Your ref:	MBNL Cat B, 73975 - Victoria ...	Please reply to:	Fraser Fikrie
Our ref:	21/04154/FULL	Tel No:	0753424 7967
		Fee Queries:	0207 641 6500;
		Email:	planningreception@westminster.gov.uk;
Mr Mark Flaherty Waldon Telecom Waldon Telecom 101 Phoenix House Pyford Rd West Byfleet KT14 6RA UK		Incomplete Applications Development Planning City of Westminster PO Box 732 Redhill, RH1 9FL	25 June 2021

Address: Victoria Park Plaza Hotel, 239-251 Vauxhall Bridge Road, London, ,

Proposal: Replacement of 4 antennas with 6 antenna apertures mounted across 3 steel support structures (2No. 41.90m AGL & 1No. 41.35m AGL), 1 600mm diameter dish mounted on support pole, 1 equipment cabinet and screening all at roof-level, plus ancillary development.

Thank you for your application received on 22 June 2021. I am writing to inform you that your application is incomplete for the following reason(s):

EXISTING SITE ELEVATION A

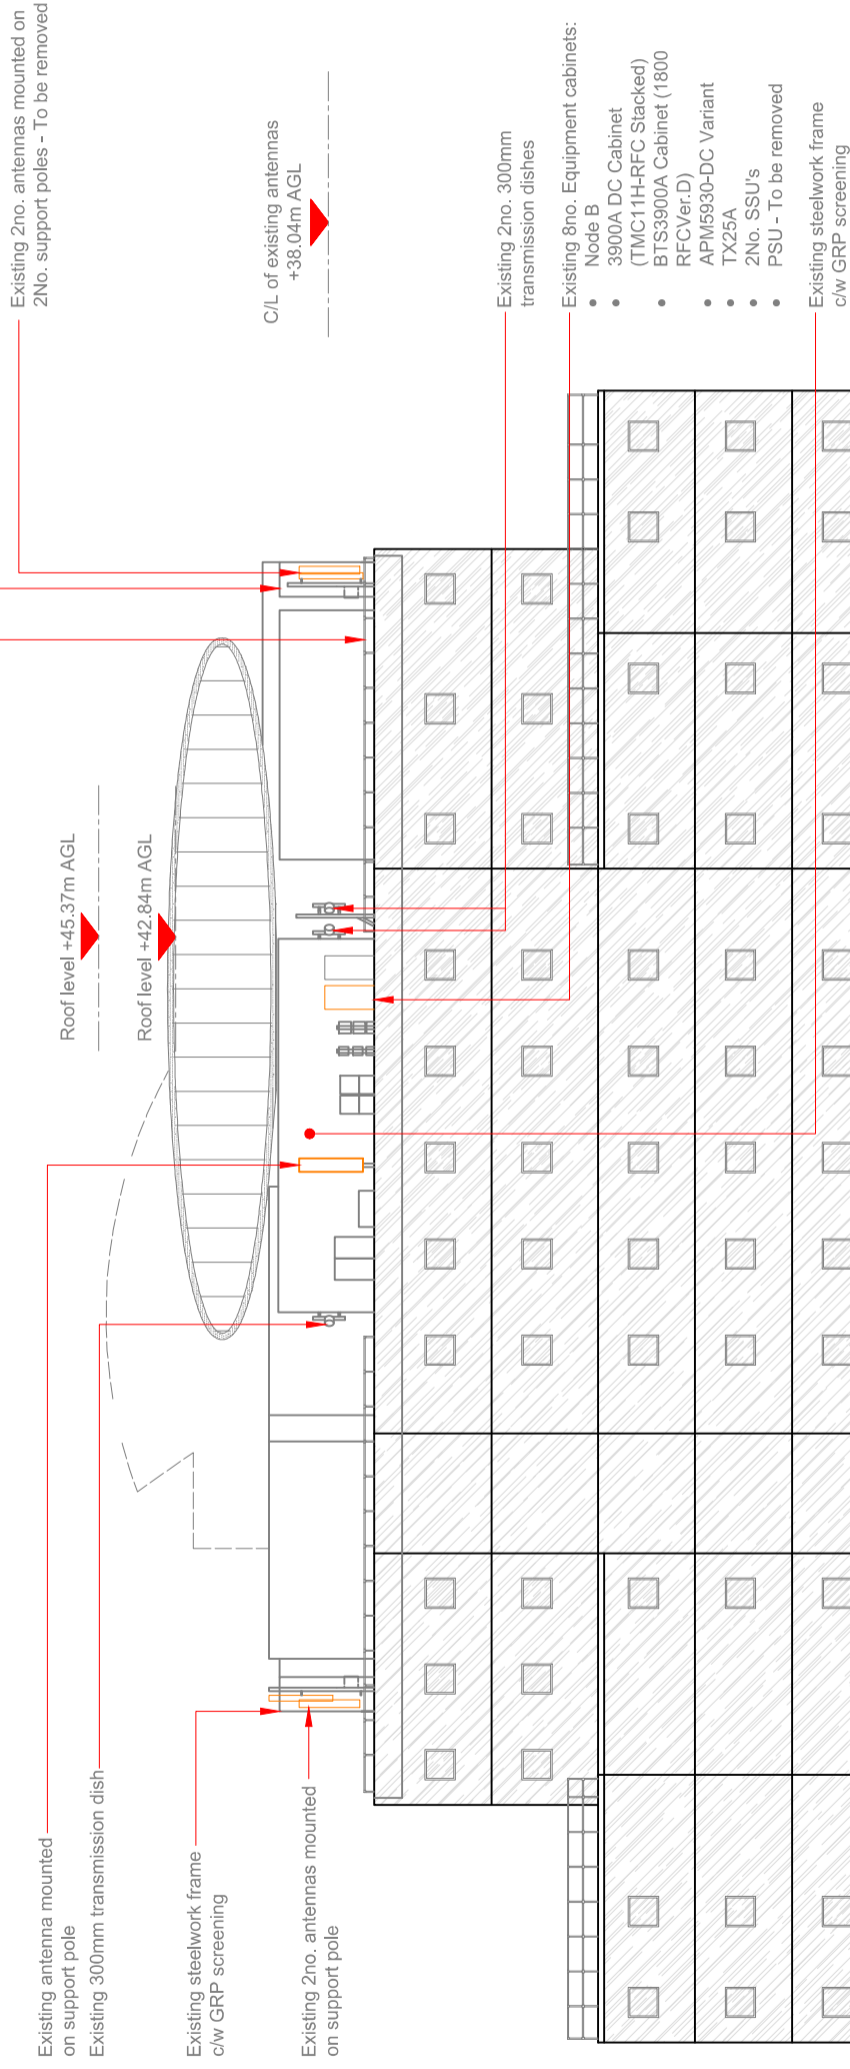
1 You have only provided one side of the building elevation. We require

- existing and elevations of all the sides of the building
